Comments on the Applicant's D5 Submissions

This document sets out the comments on the Applicant's Deadline 5 (D5) submissions by Cambridgeshire County Council (**CCC**). The tables below set out the document in question that the Council is commenting on, together with the relevant paragraph or reference number.

6.2 Appendix 13C Framework Construction Traffic Management Plan and Travel Plan (Tracked) - Rev: 04 [REP5-015] and all Appendices (A to G) [REP5-016 to REP5-042]

VEHICLE BODY	VEHICLE BODY PATH	VEHICLE WHEELS PATH
--------------	-------------------	---------------------

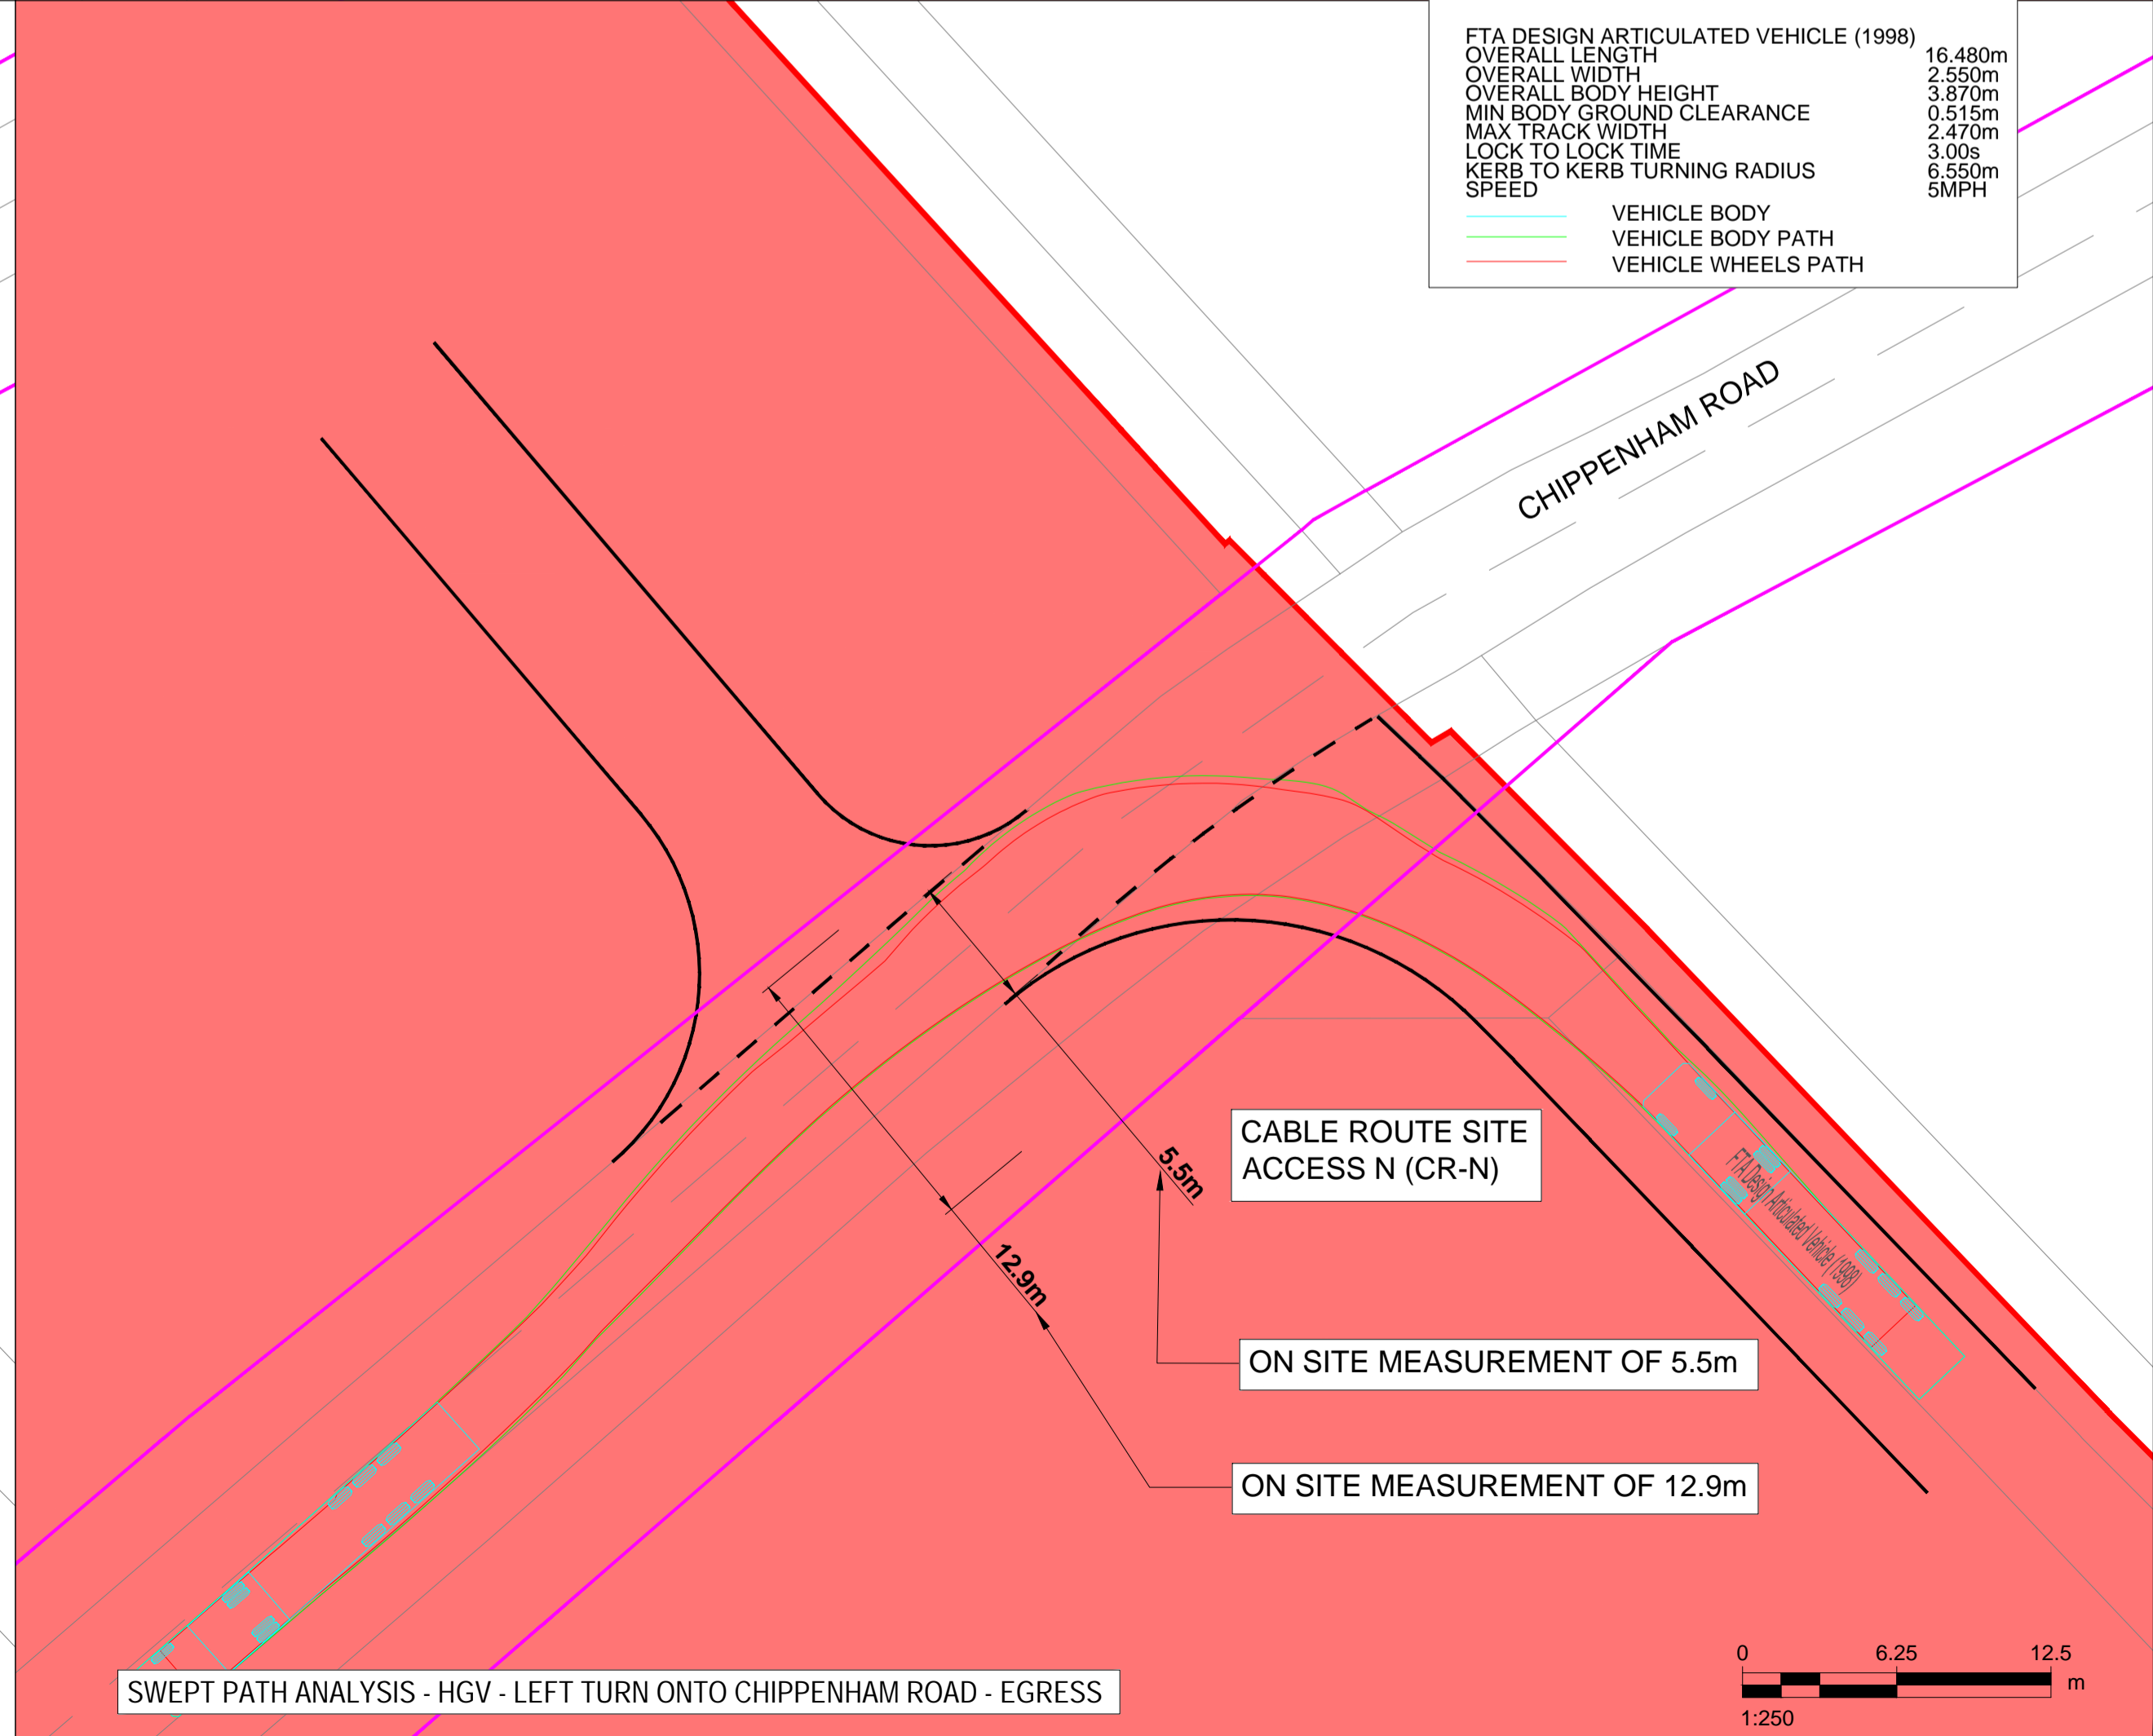
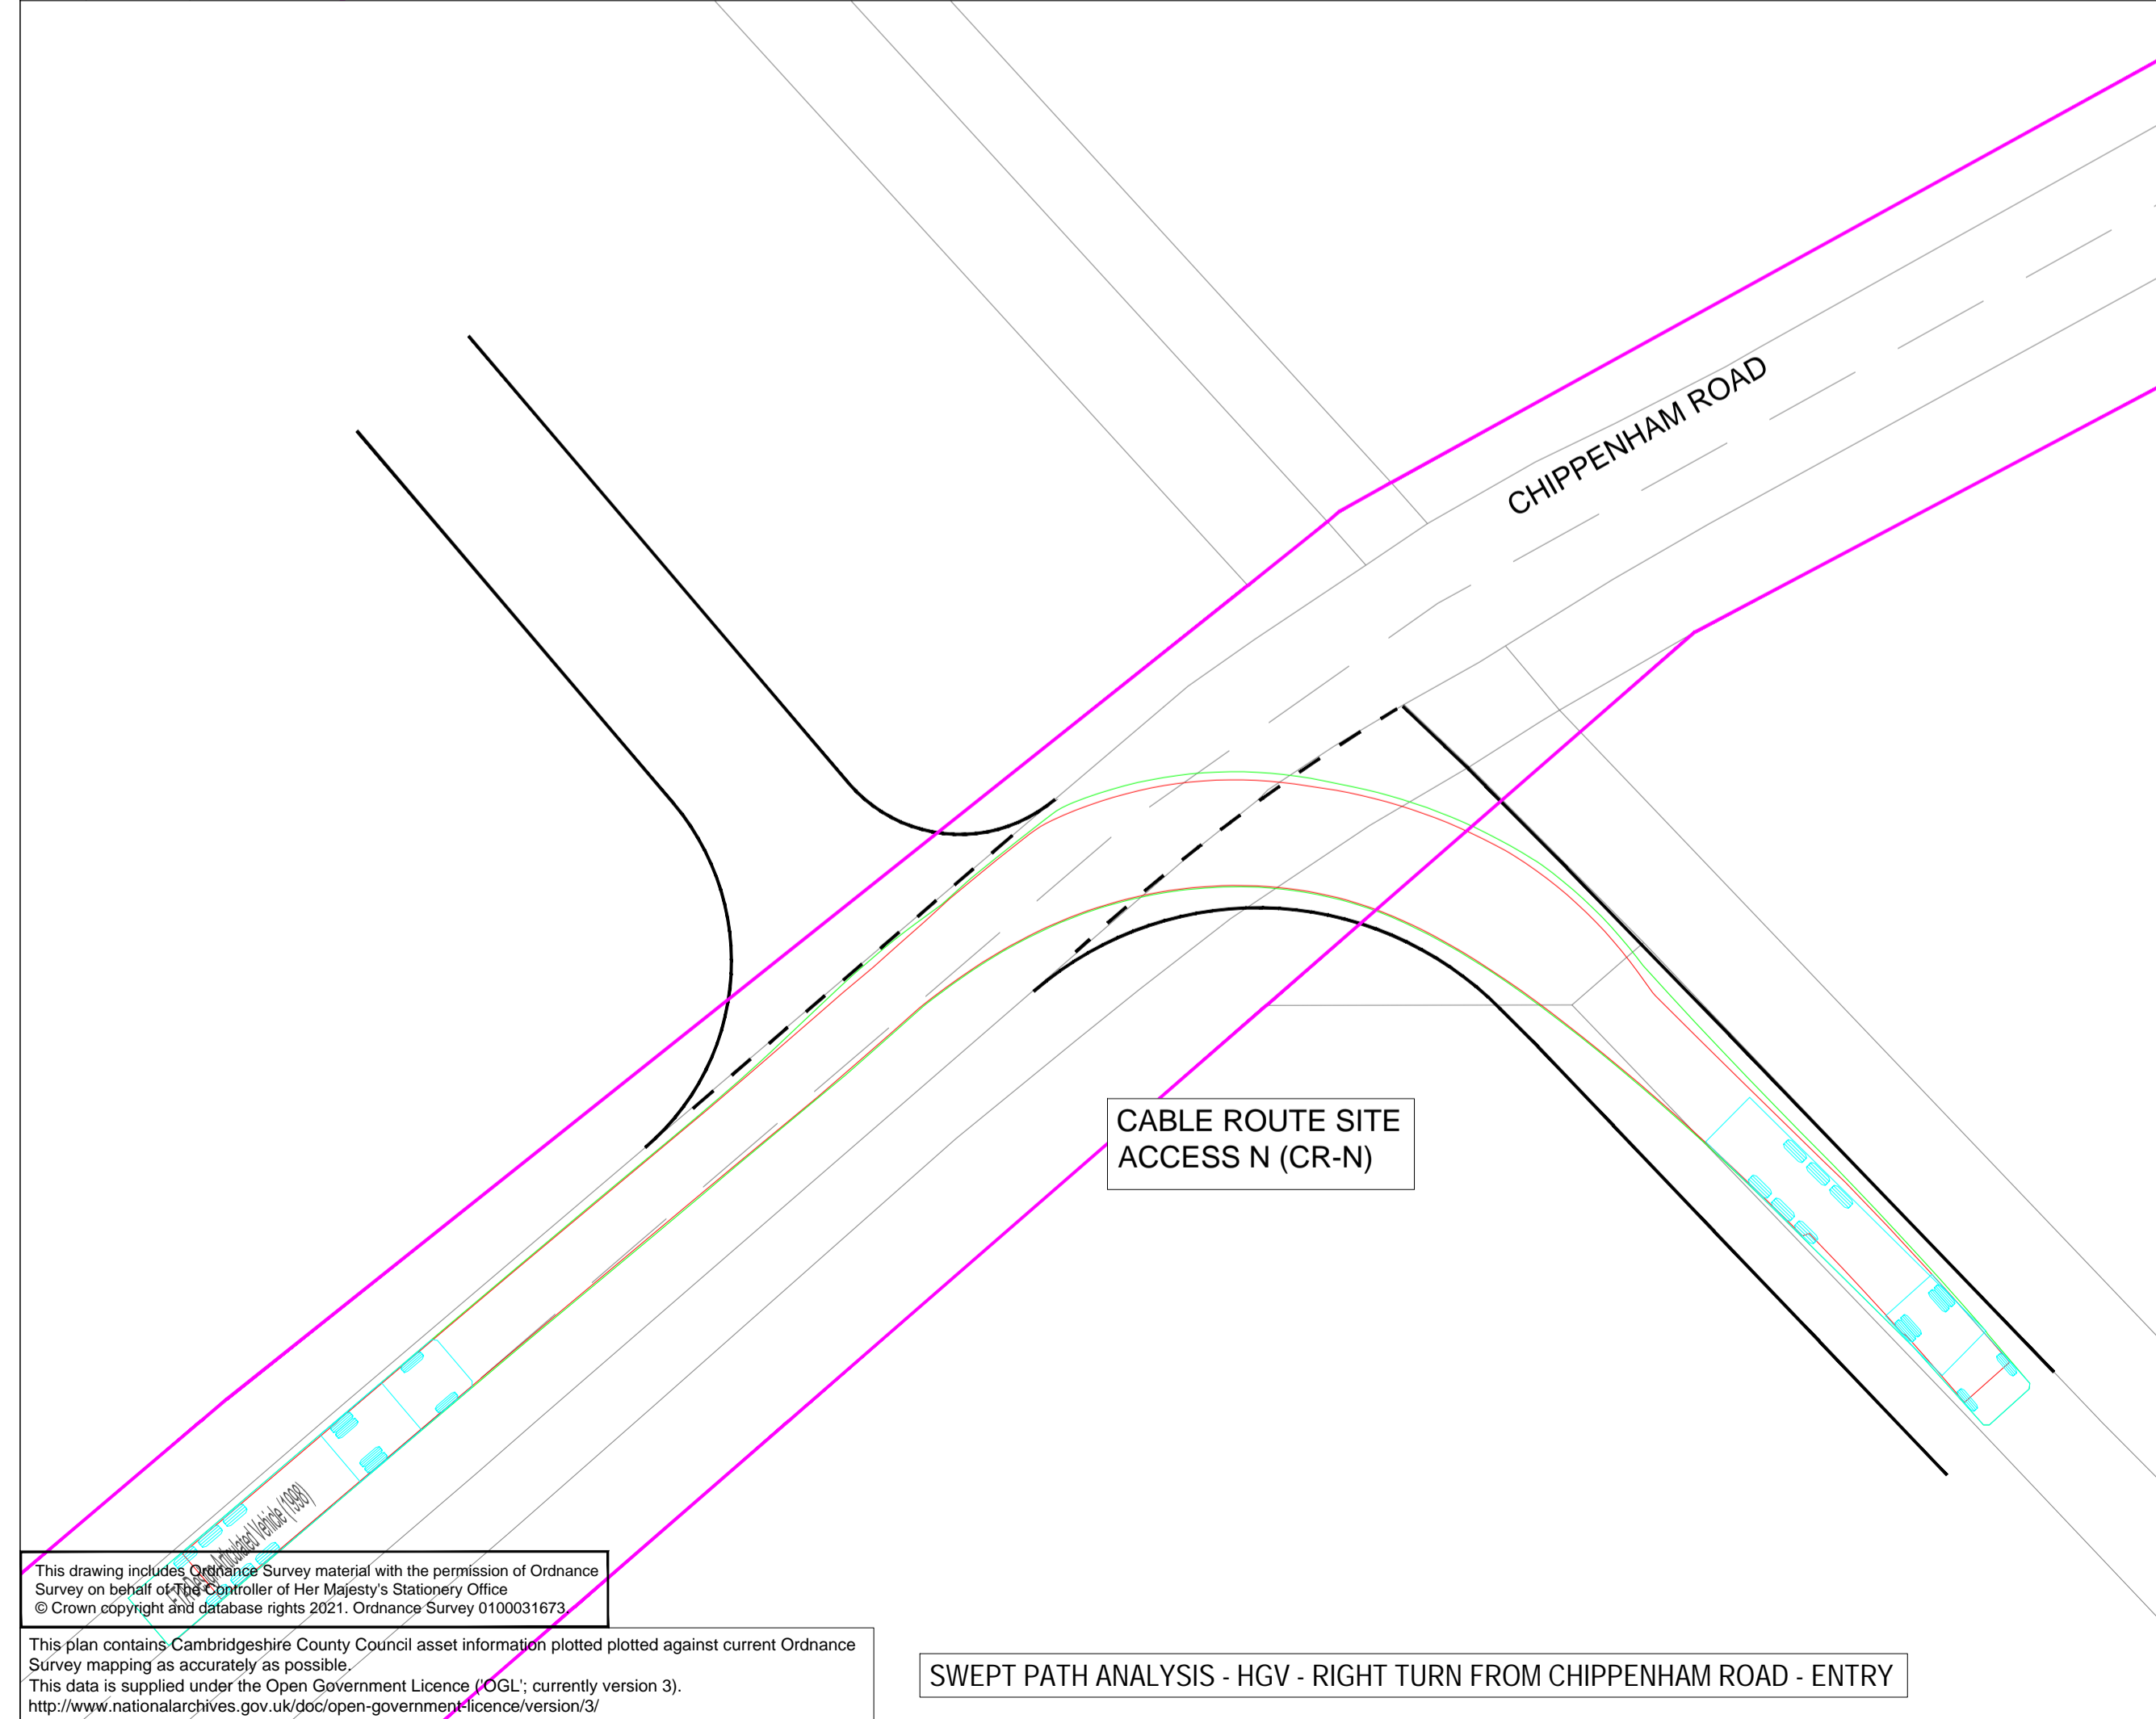
Plan ACM-60589004-AMR-DR-0038	Cable Route Access N. Snailwell Road, Chippenham.	<p>The proposal is to utilise an existing unmade field access, with improvements including 14m radius to the east but no radius to the west. This would not be considered acceptable unless it can be proven that traffic will not enter the access from the east during any phase of its use. It is also noted that any radius on the eastern side would conflict with an adjacent access and any proposal would therefore need to accommodate this.</p> <p>The swept path detail shown does not demonstrate the ability for two vehicles to pass, and while vehicle movements will be managed during the operational phase to avoid opposing flows, it is unclear how the access will be used during the operational phase, or how such conflict will then be managed. It is therefore unclear whether safe access is provided.</p>

<p>No visibility splays have been detailed to demonstrate that visibility appropriate to the speed of the road can be achieved within the DCO or Highway boundary. Chippenham Road is planted with low trees to the west and with a dense hedge to the east, creating a significant risks obstruction of visibility; this is of particular concern to the east, with this access located on the inside of the bend. It is not therefore possible to confirm that safe access can be achieved</p>
Plan ACM-60589004-AMR-DR-0038	Cable Route Access O. La Hough Road, Chippenham.	<p>The proposal is to utilise an existing unmade access which it appears to share with an existing dwelling. Improvements are proposed, with 12m radius to the east and 6m radius to the west, which appear broadly acceptable for the use and speed of the road.</p> <p>The swept path detail shown does not demonstrate the ability for two vehicles to pass, and while movement will be managed by traffic signals during the construction phase, it is unclear how the access will be used during the operational phase, or how such conflict will then be managed. It is therefore unclear whether safe access is provided.</p> <p>No visibility splays have been detailed to demonstrate that visibility appropriate to the speed of the road can be achieved within the DCO or Highway boundary. It is not therefore possible to confirm that safe access can be achieved during the operational phase in the absence of traffic management.</p>
